WEST SUSSEX COUNTY COUNCIL CONSULTATION

TO:	Arun District Council FAO: Mr S Davis
FROM:	WSCC - Highways Authority
DATE:	16 March 2022
LOCATION:	36 Carlton Avenue Bognor Regis PO21 3LR
SUBJECT:	AW/47/22/DOC Approval of details reserved by condition imposed under AW/130/18/OUT relating to condition 8-Construction Environmental Management Plan.
DATE OF SITE VISIT:	n/a
RECOMMENDATION:	More Information
S106 CONTRIBUTION TOTAL:	n/a / £ See below for breakdown.

Construction Environmant Management Plan (CEMP) at 1 : 5 0 0 s c a l e

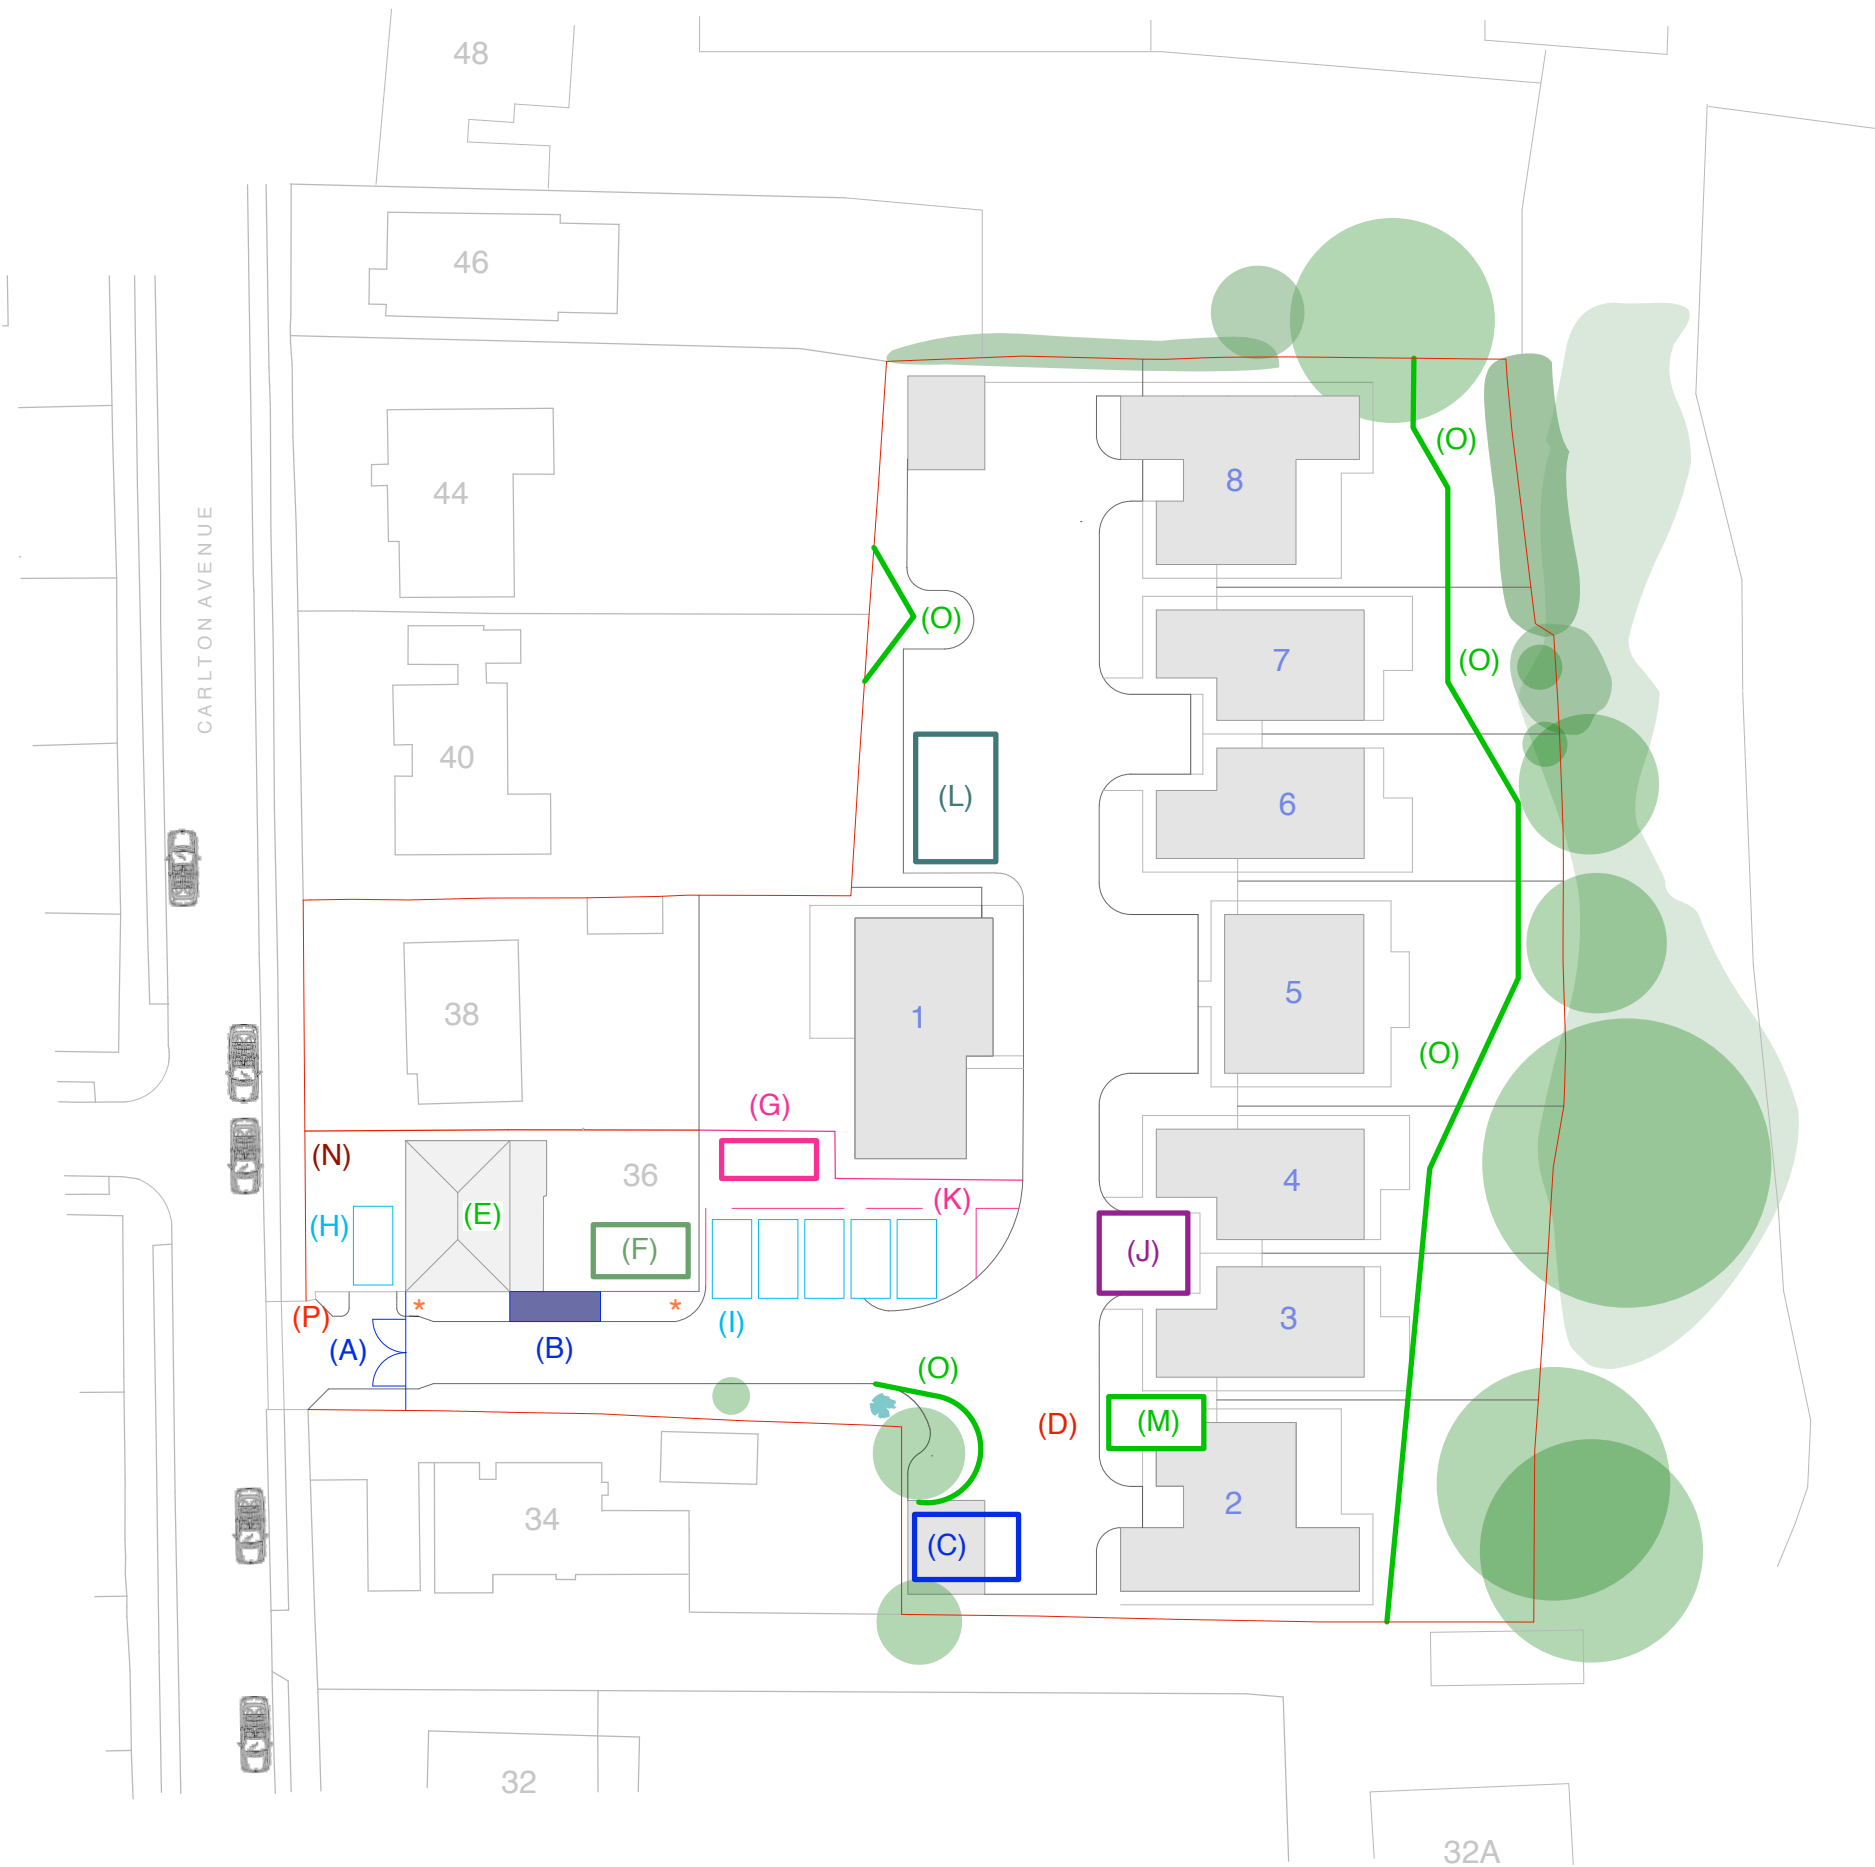
Given the proximity to the Primary School and the parking demands for the area it is advised the delivery school operating times are checked as schools often finish at 3pm. If this is the case and considering the demand for parking at school time the delivery window may have to be restricted to 9am - 2.30pm. In addition, a qualified banksman is required to managed deliveries.

There appears to be a large hedge bounding the highway to the north of the access. This will need to be removed/lowered prior to construction to allow for 2m x 2m pedestrian visibility and improve vehicular visibility.
